Item No. **Report of the Head of Planning, Transportation and Regeneration**

Address 139 BURY STREET RUISLIP

Development: First floor rear extension, conversion of roof space into habitable use to include front and rear rooflights, alterations to the existing conservatory to form a flat roof single storey rear extension (including external alterations) and new side and rear windows/doors

LBH Ref Nos: **20795/APP/2021/2836**

B99580 - 3200 A

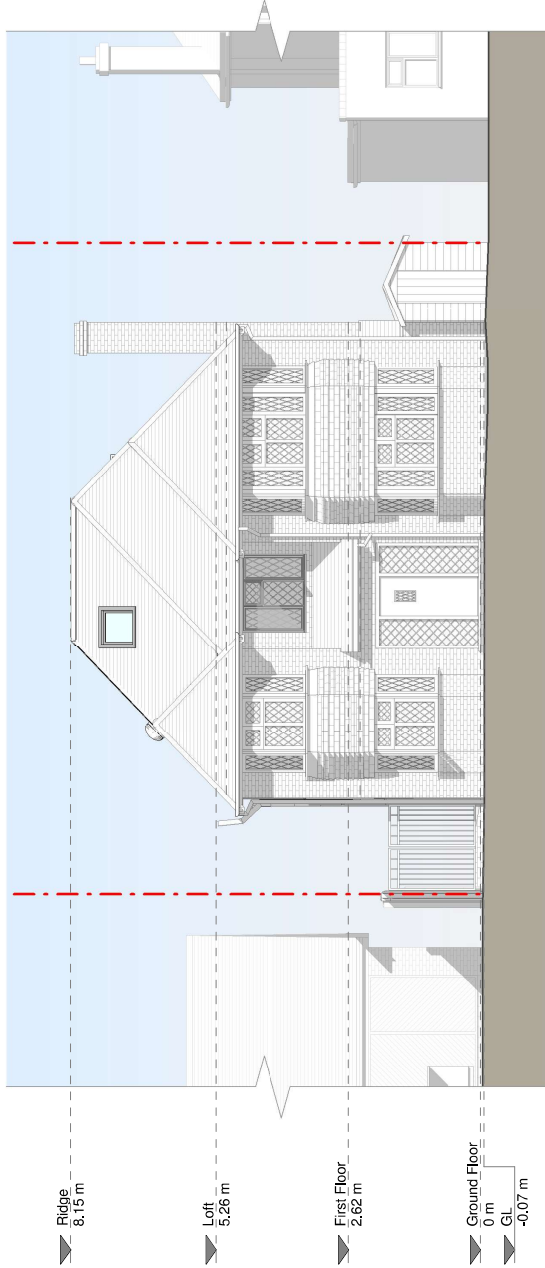
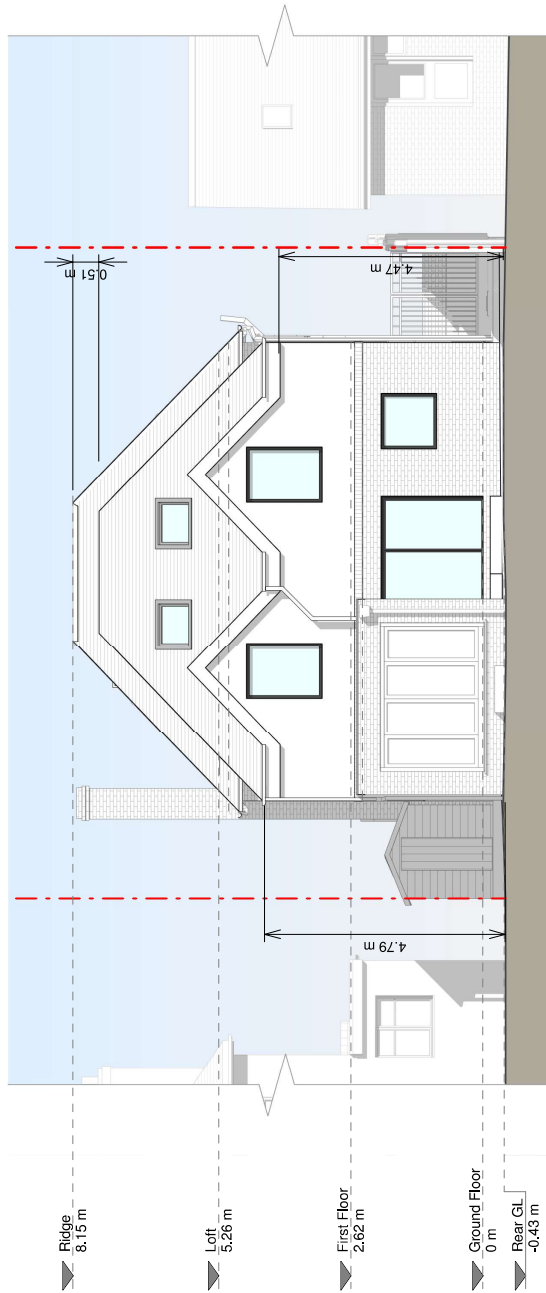
The existing hipped roof of the single storey full width extension would be removed with a full width first floor rear extension at approx. 3.2m in depth. The proposed addition would add substantial bulk and massing to the dwelling resulting in a top heavy, dominant, incongruous, visually intrusive and excessive form of development.

The proposed addition would overpower the host dwelling and despite the set down from ridge and eaves level, the combined height, depth and in particular width alongside its siting would result in a dominant and disproportionate addition that would harm the original architectural composition of the dwelling.

To some degree, the existing roof form is complicated. However, the proposal would make the situation substantially worse by adding an awkwardly and incongruously designed first floor addition (and its roof) that would appear jarring and visually intrusive. The two rear gabled elements would appear confused features that would exacerbate the overall bulk and massing. Furthermore, the proposed addition would create a large crown roof element that would add excessive massing resulting in the proposed addition being wholly unacceptable.

The host dwelling is predominantly finished in dark brick with the front elevation at first floor having hanging tiles. The proposed alterations at ground level would be finished in brick work. However, the first floor element would be finished in white render which is not common of the original dwelling. A varying material palette is noted in the area and given the rear siting, to some degree this would not be wholly unacceptable as a refusal reason alone. However, the use of render would contribute to the visual intrusion and jarring nature the proposal would bring.

DRAWING NO. B99580 - 3101 A

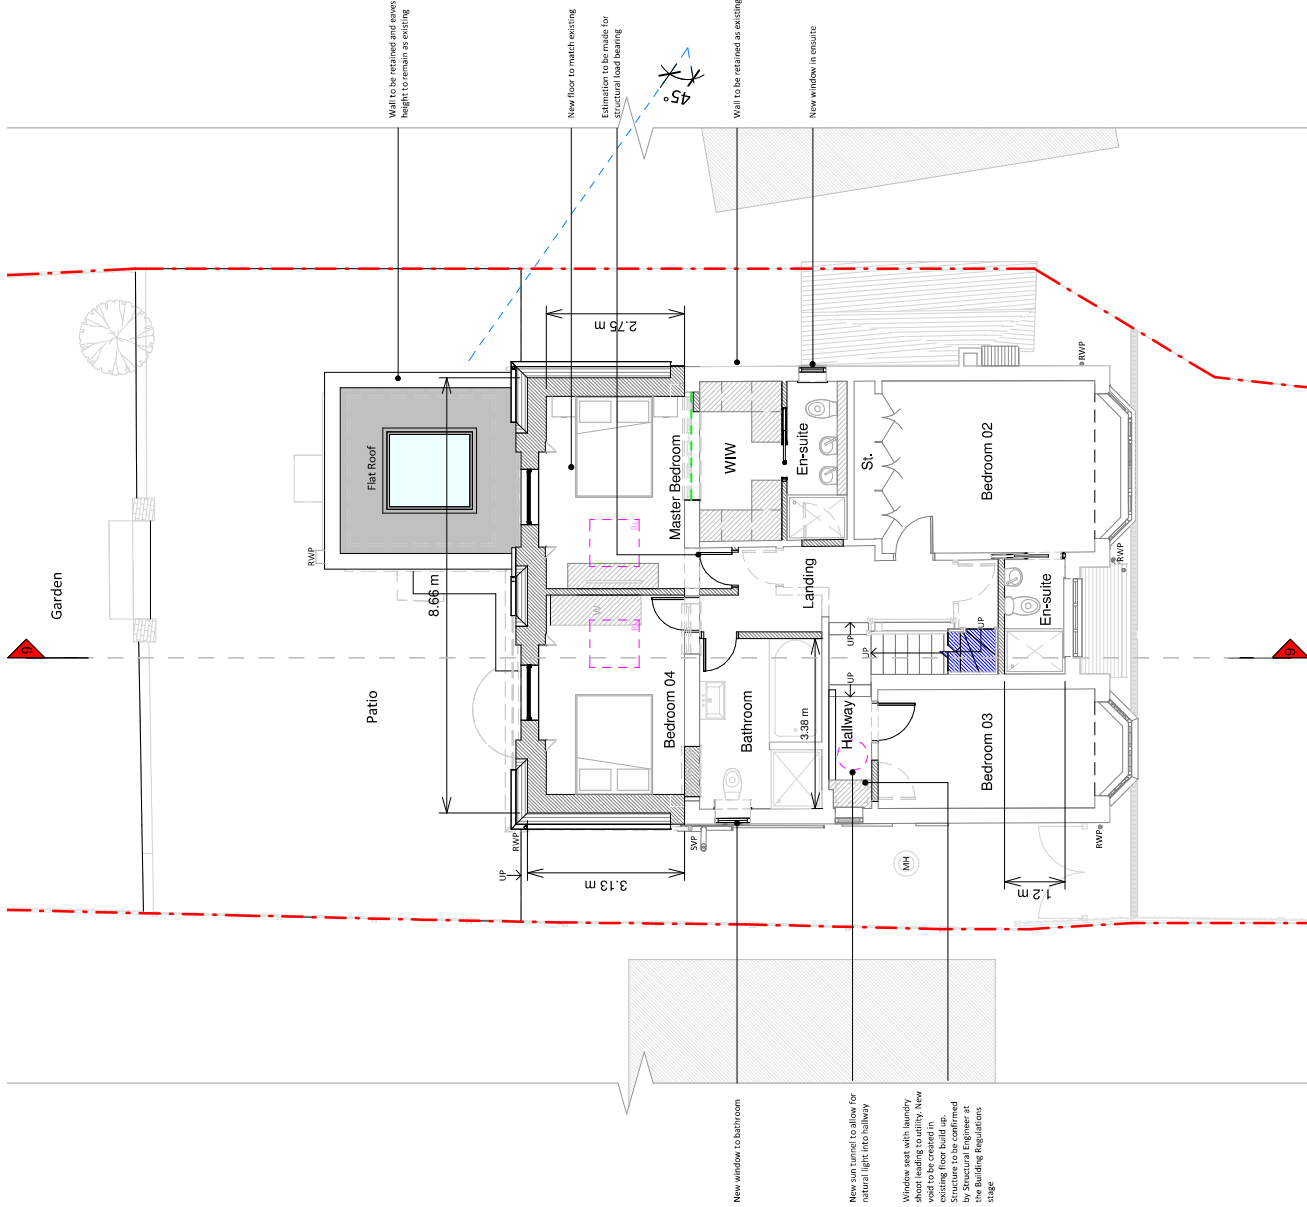
The host dwelling is approx. 8m deeper than no.141. There is an approx. 2m separation to the common boundary. As the conservatory would be reduced in height, with no enlargement in width or depth, it is considered this element would not be detrimental. No.141 has an original part rear projection along the side of no.143 but has not been extended. It is noted there is an immediate rear window of the side extension, rear door and rear doors/windows of the original rear projection element. There are three first floor rear windows. It is important to note that the submission has failed to provide an internal layout check of the adjacent dwellings and demonstrate 45 degree compliance from all habitable primary facing rear windows. The proposed first floor plan does show some form of line but it is not clear where this has been taken from.

Regardless, the proposed first floor rear extension would extend 3.2m in depth which would be in line of no.141, especially as given the bend of the road, the dwelling is more in the view of the host dwelling and its proposed extension. The adjacent dwelling has not been extended and given the combined height, width and depth of the proposed first floor extension and its close proximity, it is considered this addition would result in substantial harm to the occupiers in terms of terms of overdominance, outlook, sense of enclosure, visual intrusion, loss of privacy and overbearing impact. The excessive roof form and jarring/intrusive design would be excessive for the neighbour.

Whilst failure to demonstrate 45 degree compliance, it is considered the overall size of the first floor would lead to some loss of daylight/sunlight to the occupiers of no.141 - their garden area and dwelling.

DRAWING NO. B99580 - 3300 A

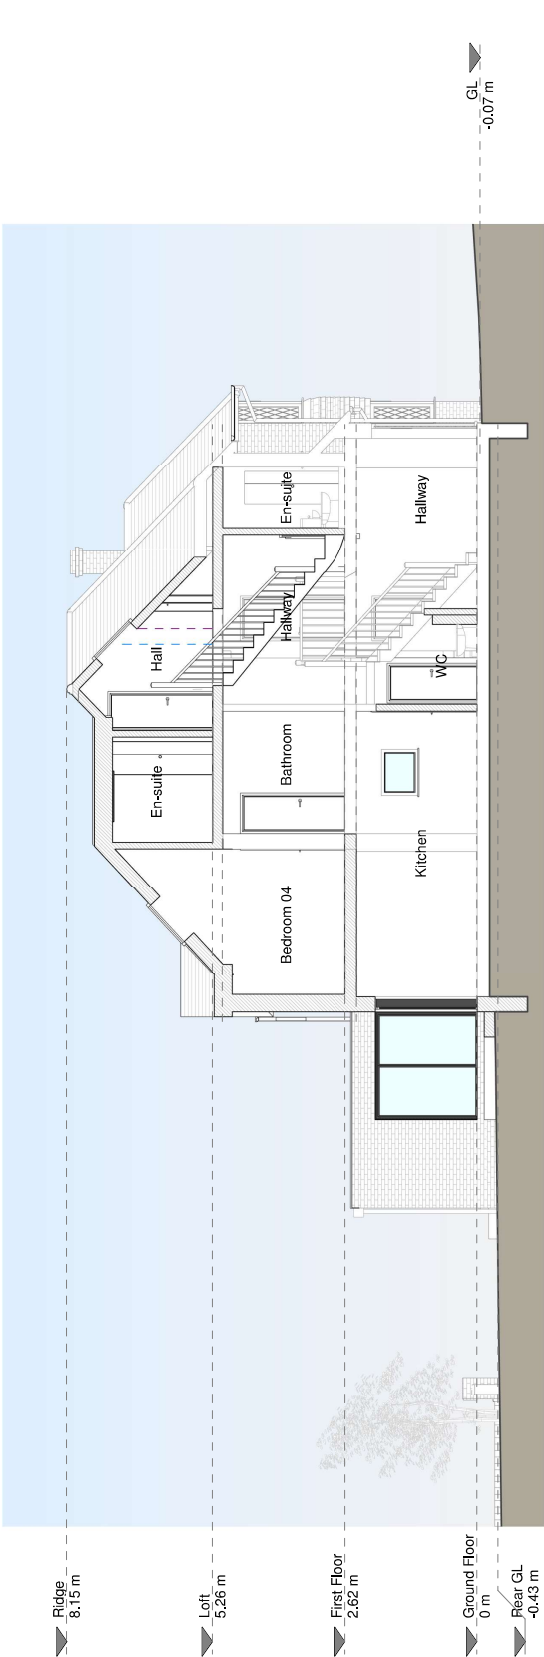
The applicant can convert the current roofspace into habitable accommodation without the need of planning permission. This would be the case here with the extended roof form of the first floor addition also forming part of a bedroom. 5 rooflights would serve this area for light and ventilation. Outlook in roof space will always be oblique given the angling. Only when proposing dormers can the outlook be made more acceptable. In this instance, no dormer is being proposed and given the internal conversion that can be made, it is considered that the quality of accommodation would on balance be acceptable.
